**From:** Laura Gibbons <Laura.Gibbons@arun.gov.uk>  
**Sent:** 02 March 2021 10:16  
**To:** Planning.Responses <Planning.Responses@arun.gov.uk>  
**Cc:** Maria Tomalova <Maria.Tomalova@arun.gov.uk>  
**Subject:** RE: Planning Consultation on: BR/12/21/DOC

| <b>Description of Works:</b> | Approval of details reserved by condition imposed under ref APP/C3810/W/19/3230749 (BR/229/17/PL) relating to Condition Nos 5 - surface water drainage and 6 - discharge flows to watercourses. |

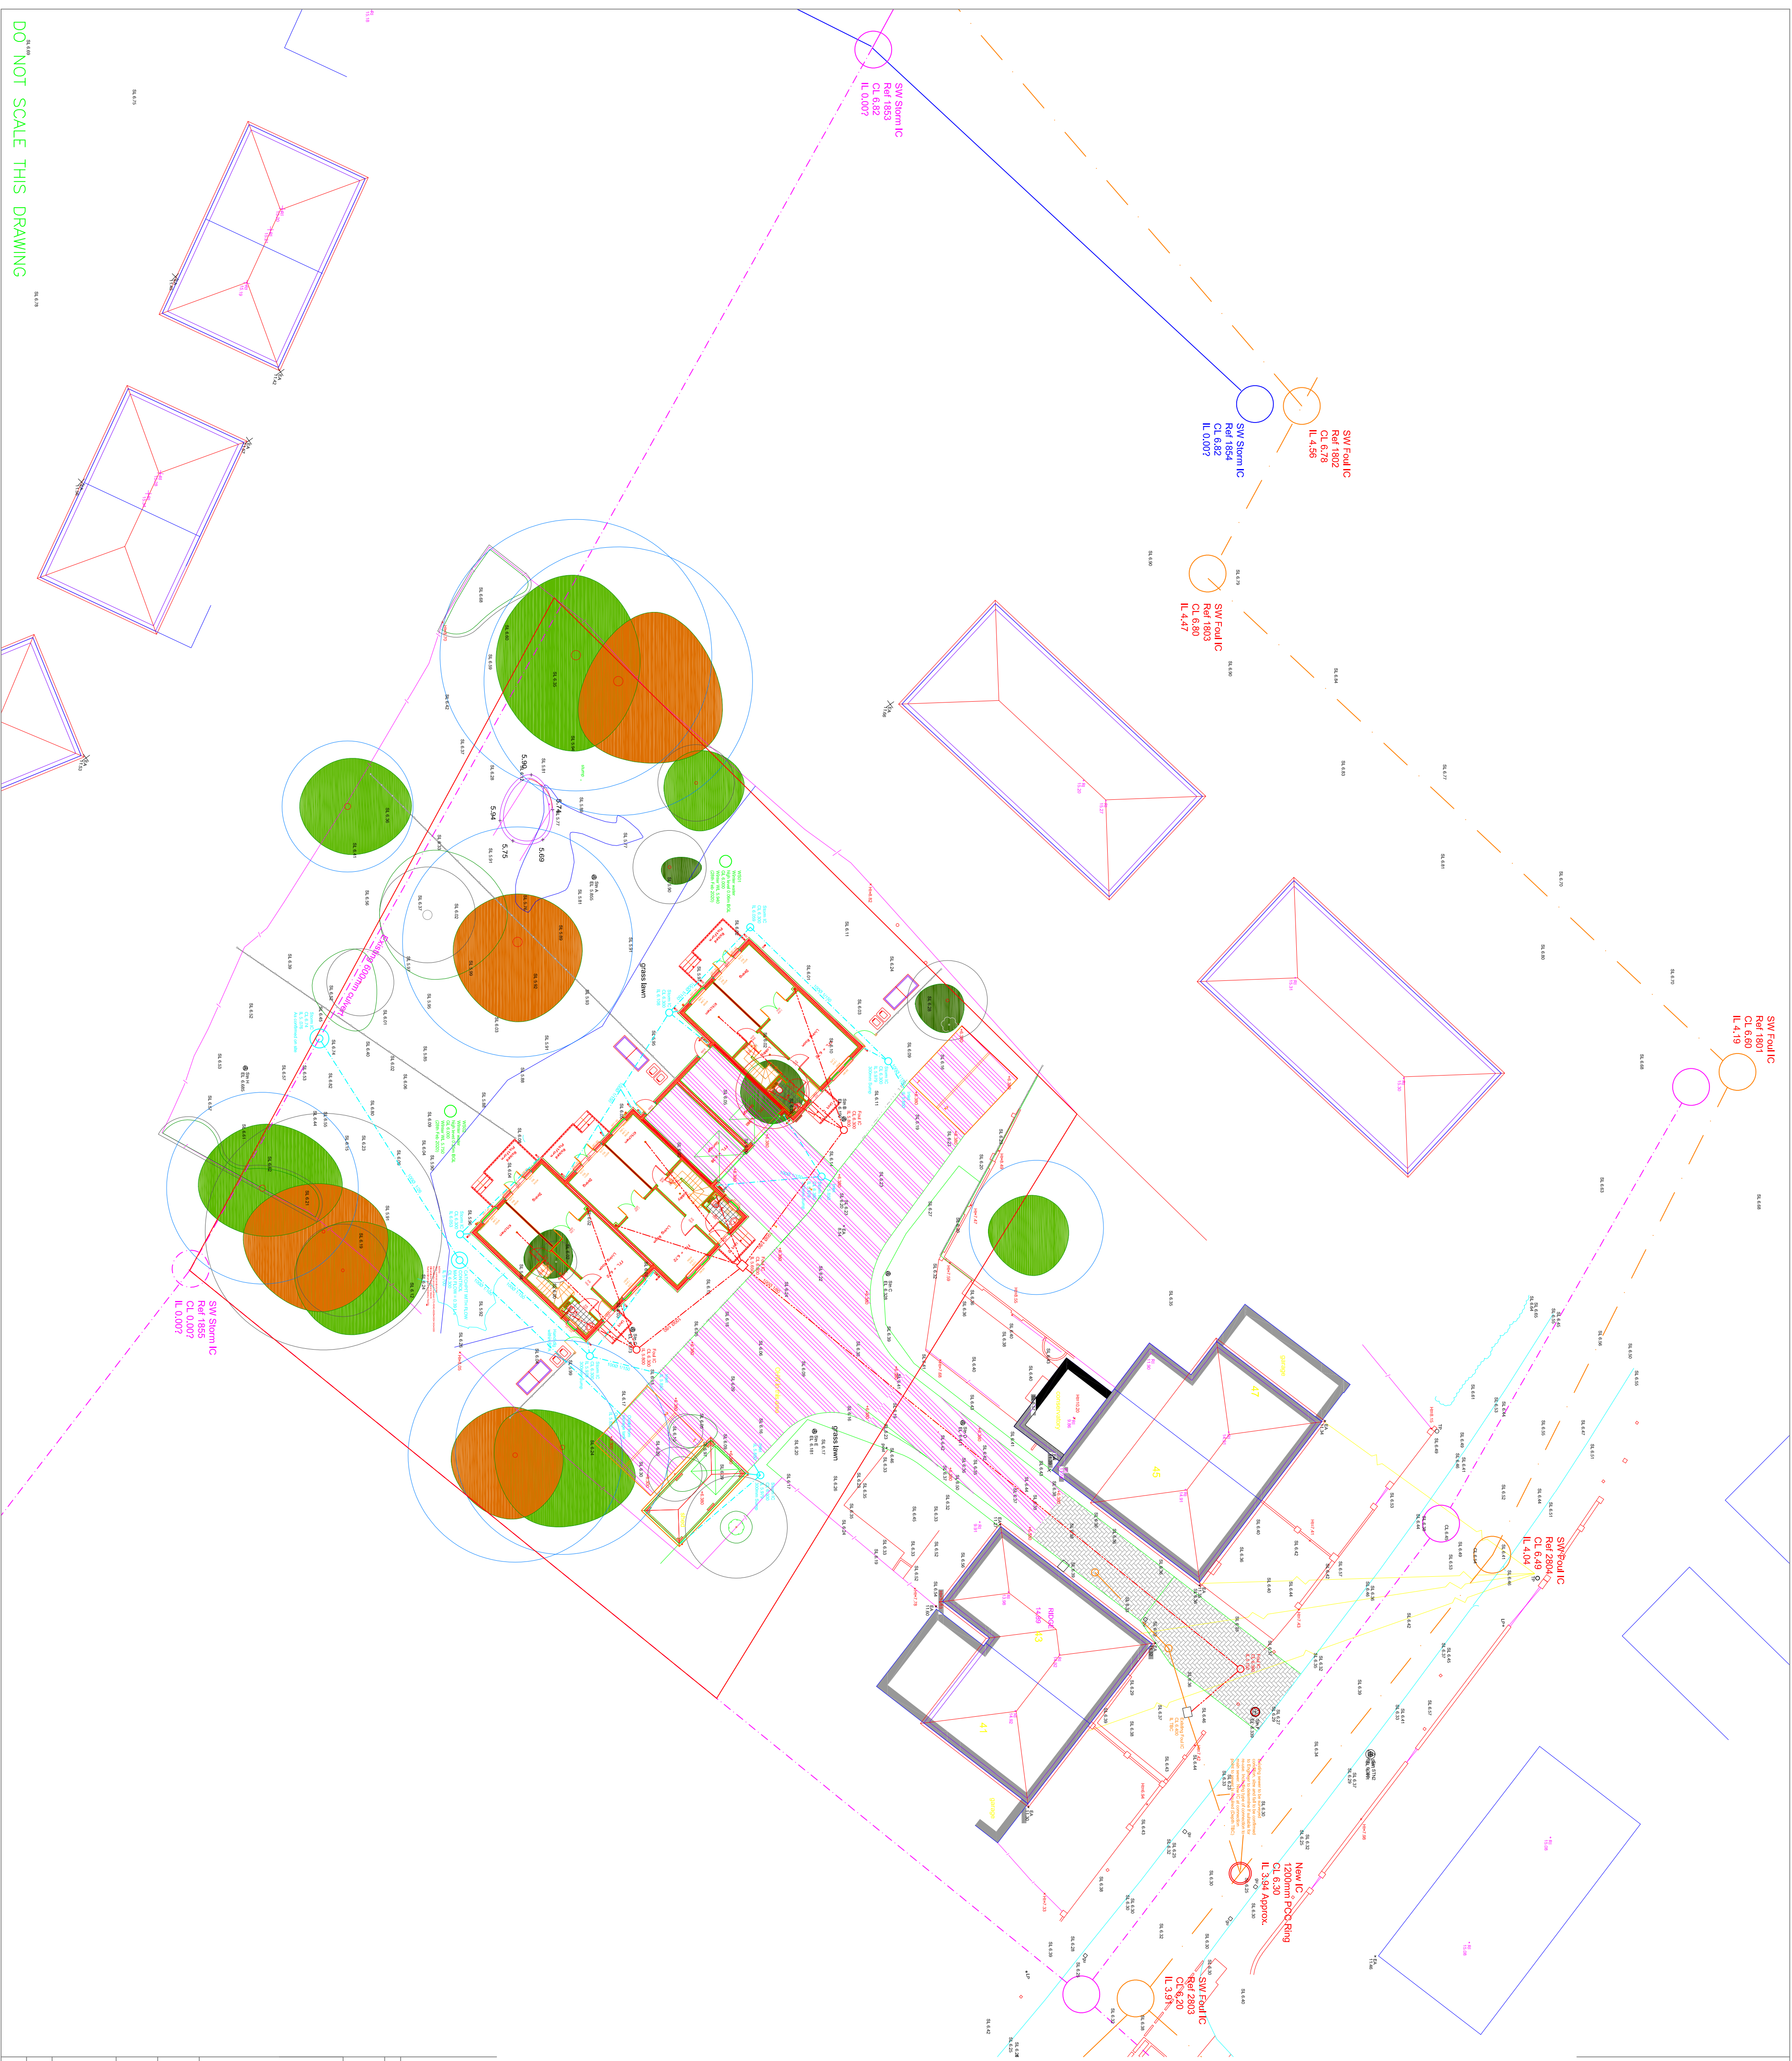
We recommend discharge of condition 5. Please ensure that the following plans are included in any approval notice:

424861-100P8 Drainage General Arrangement
